16th May 2011

Our Ref: EP/34/11/NMA

**Application for a Non-Material Amendment following a grant of
planning permission EP/124/10
to change round porthole window in north elevation to diamond
shape and render to part of elevations changed to weatherboarding
Seaside Cottage, South Strand, East Preston**

Front Elevation - North (road)

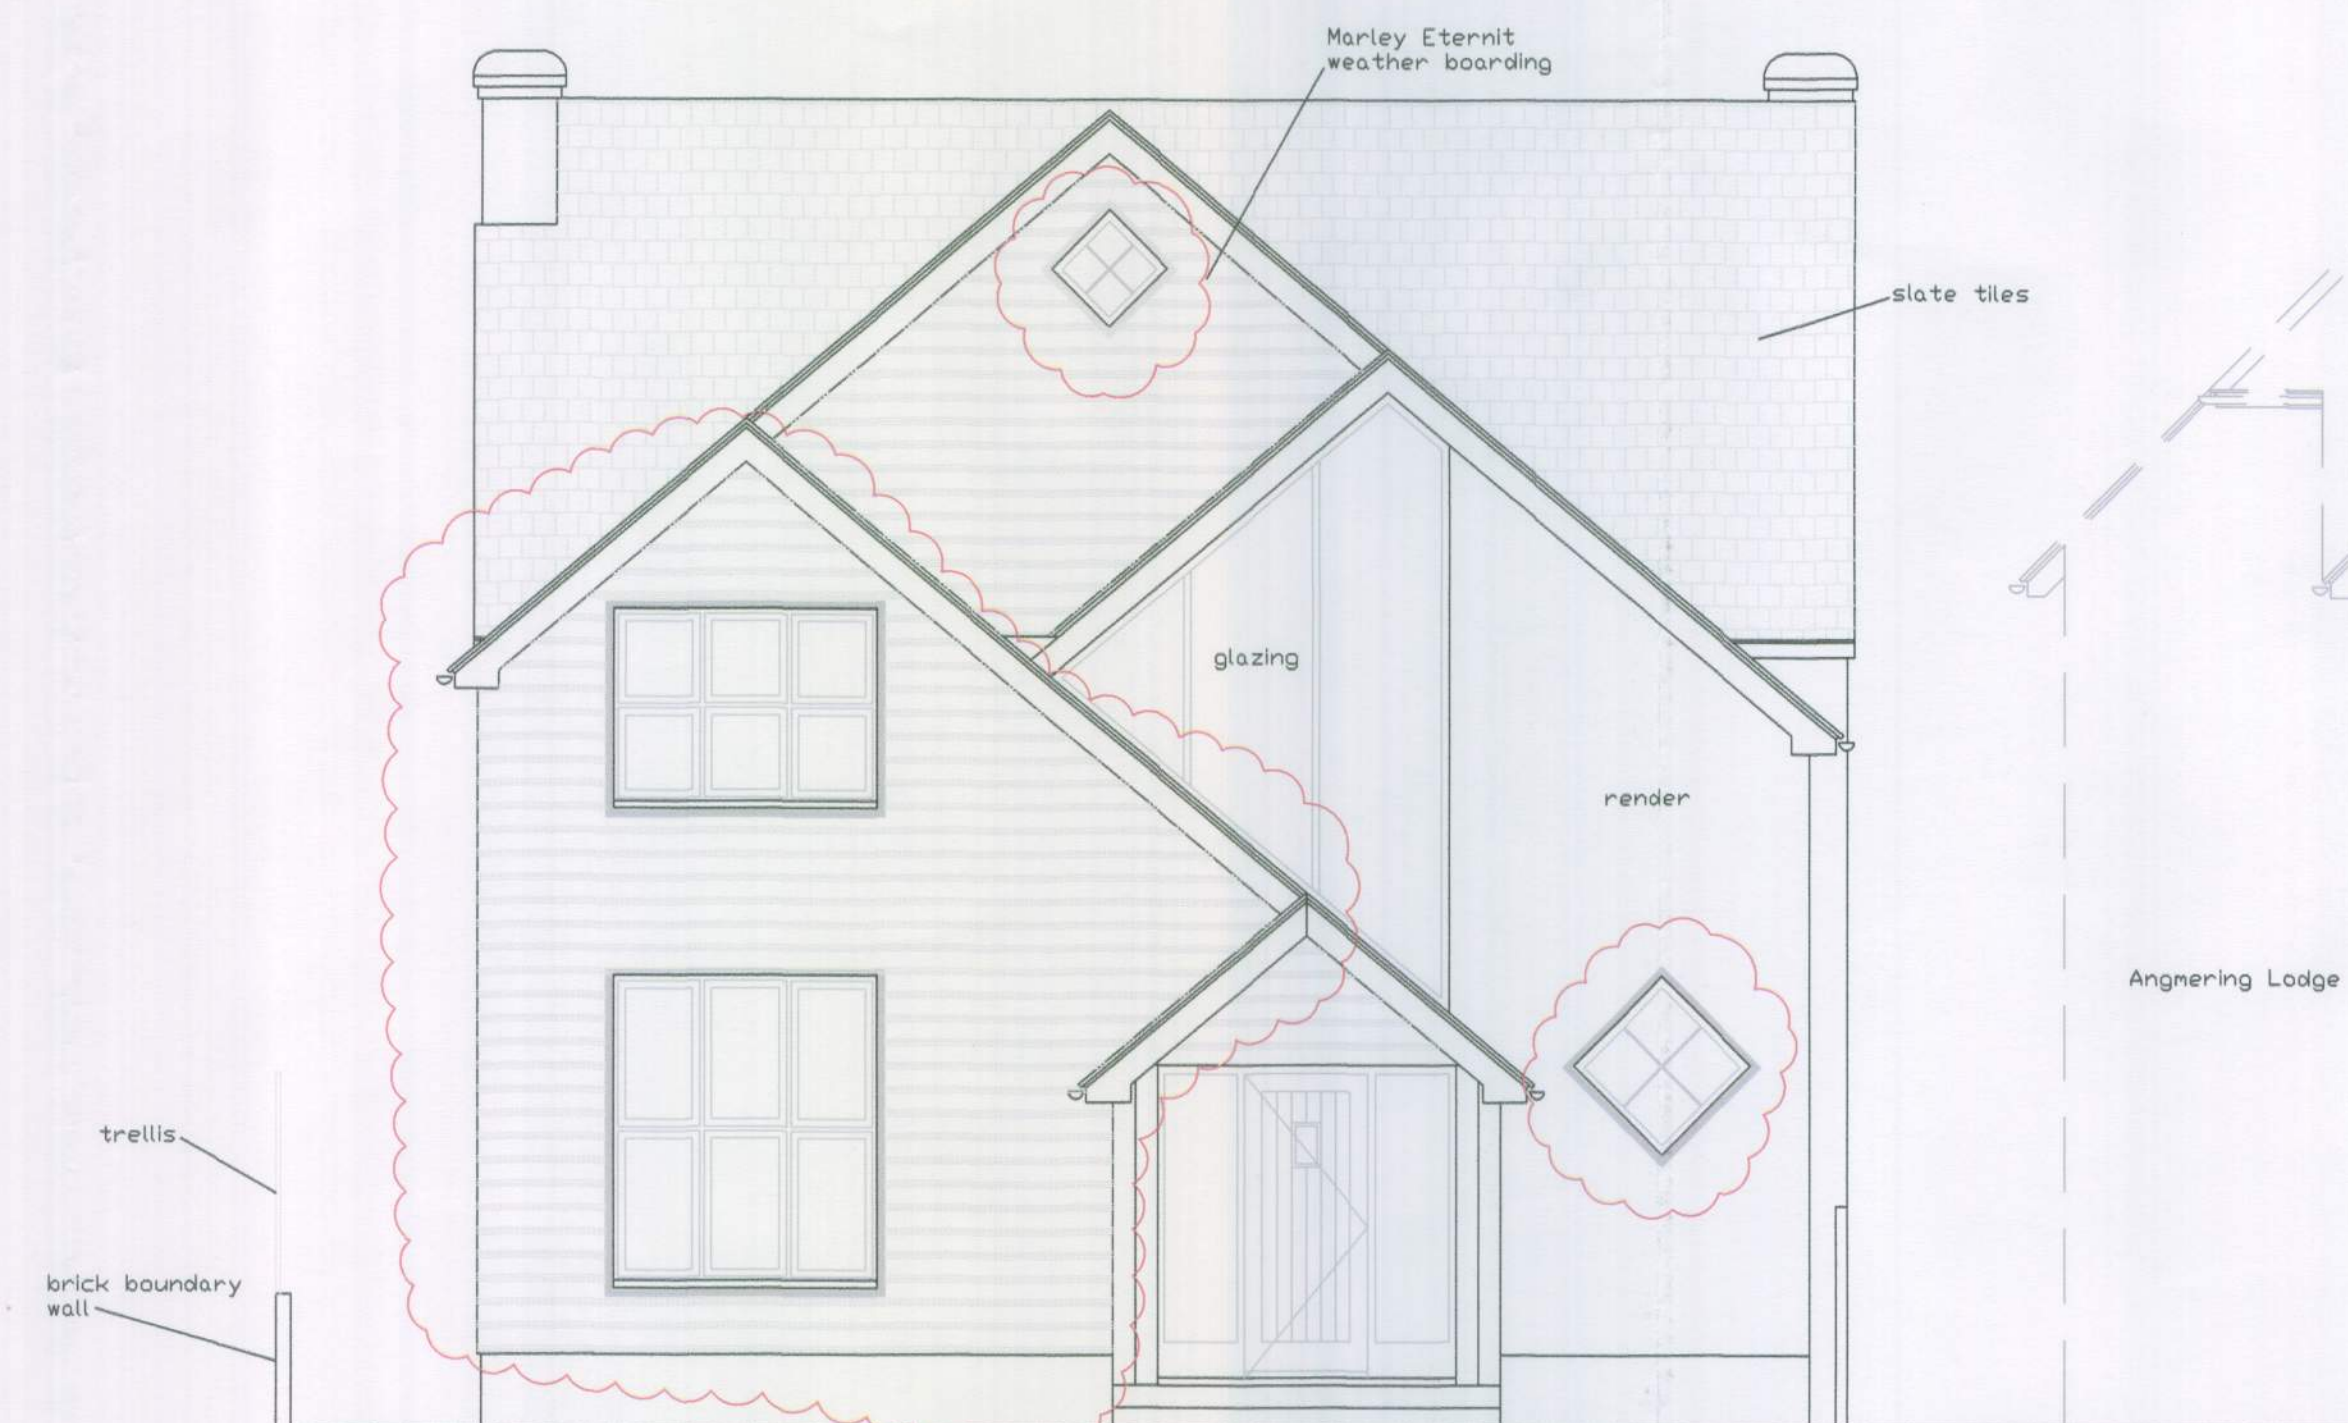
I am pleased to confirm that a diamond shape window to the north elevation to replace a porthole window together with render to part of the elevations changed to weatherboarding will be acceptable for the approved application EP/124/10. Please note that your submitted plan 10066/05A now becomes the approved plan for the development.
